Our Ref: M/9/19/HH

**Town & Country Planning Act 1990 (as amended)
Town & country Planning (Development Management Procedure) (England) Order 2015
Application for Planning Permission for Works or Extension to a Dwelling**

Development Two storey rear extension, porch to front and conversion of roof space with two front dormers

Location Fidra Yapton Road Middleton-On-Sea

Proposed First Floor Plan

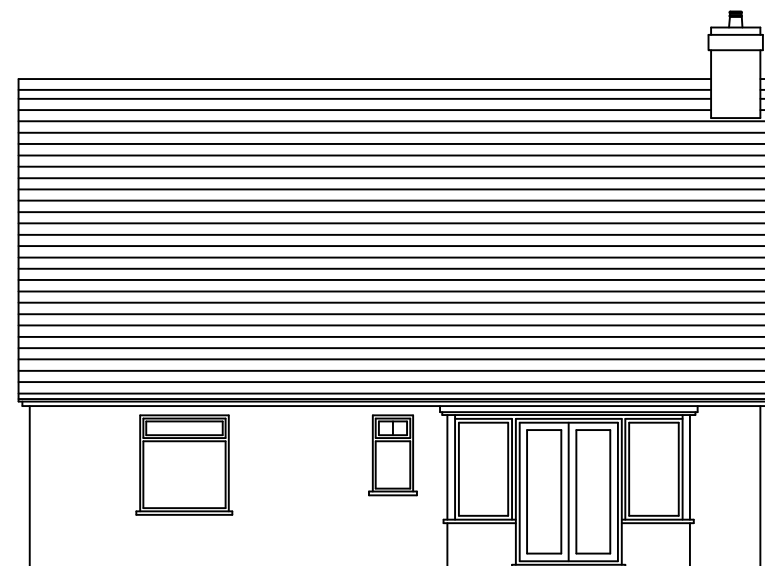
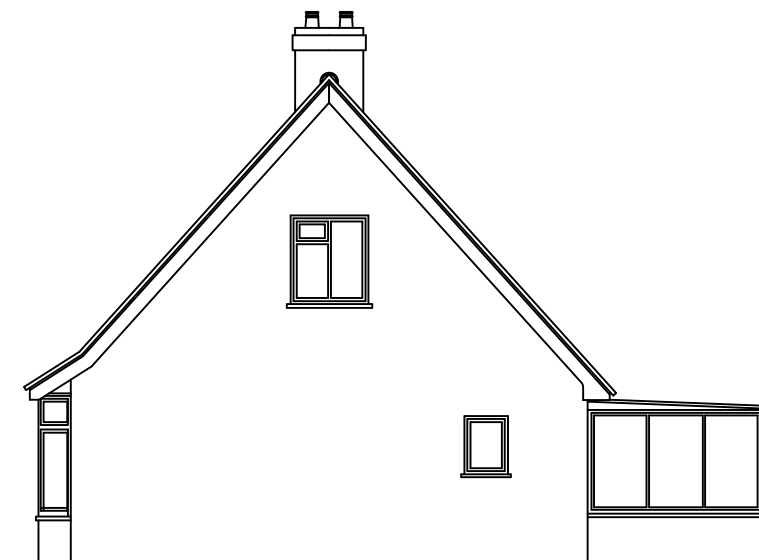
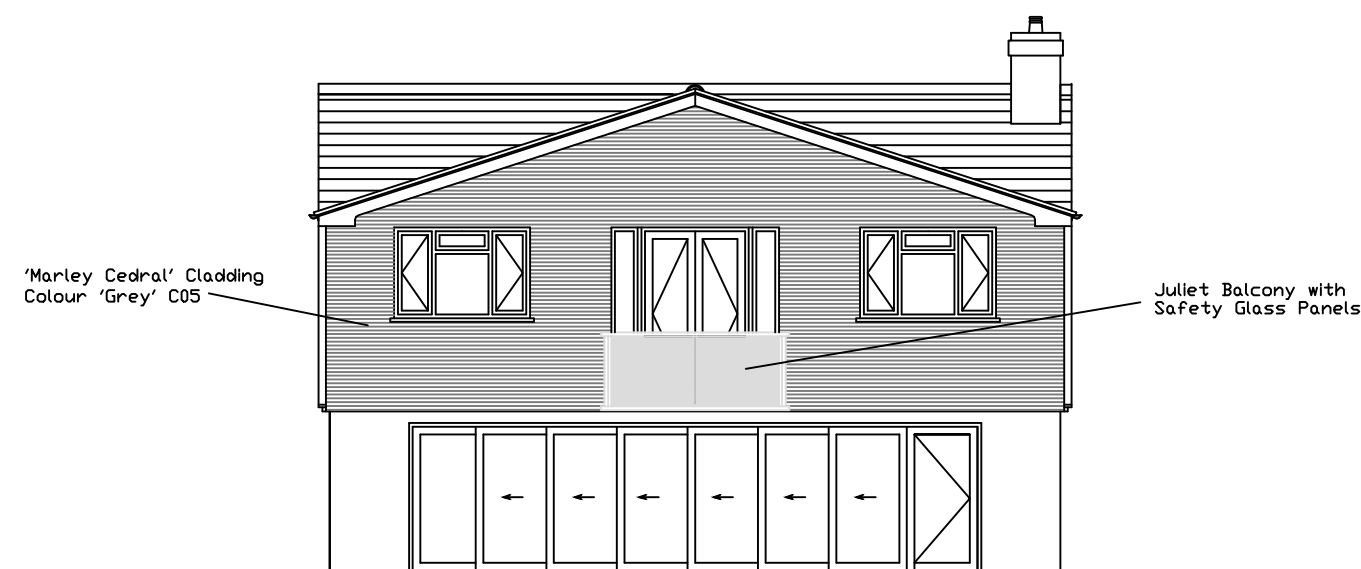
Inconsistent: The windows are inconsistent between the proposed first floor plan and side elevations.

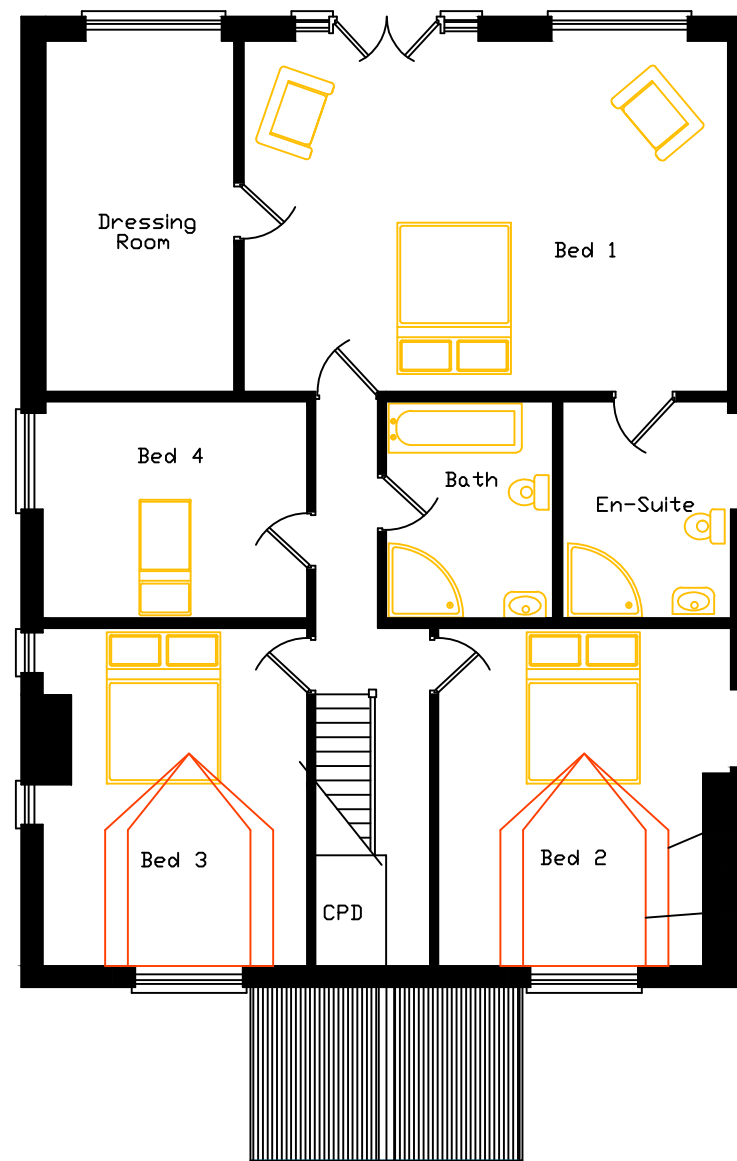
Dormers: You are required to show the shape of the dormers on the first floor plans. Please amend accordingly.
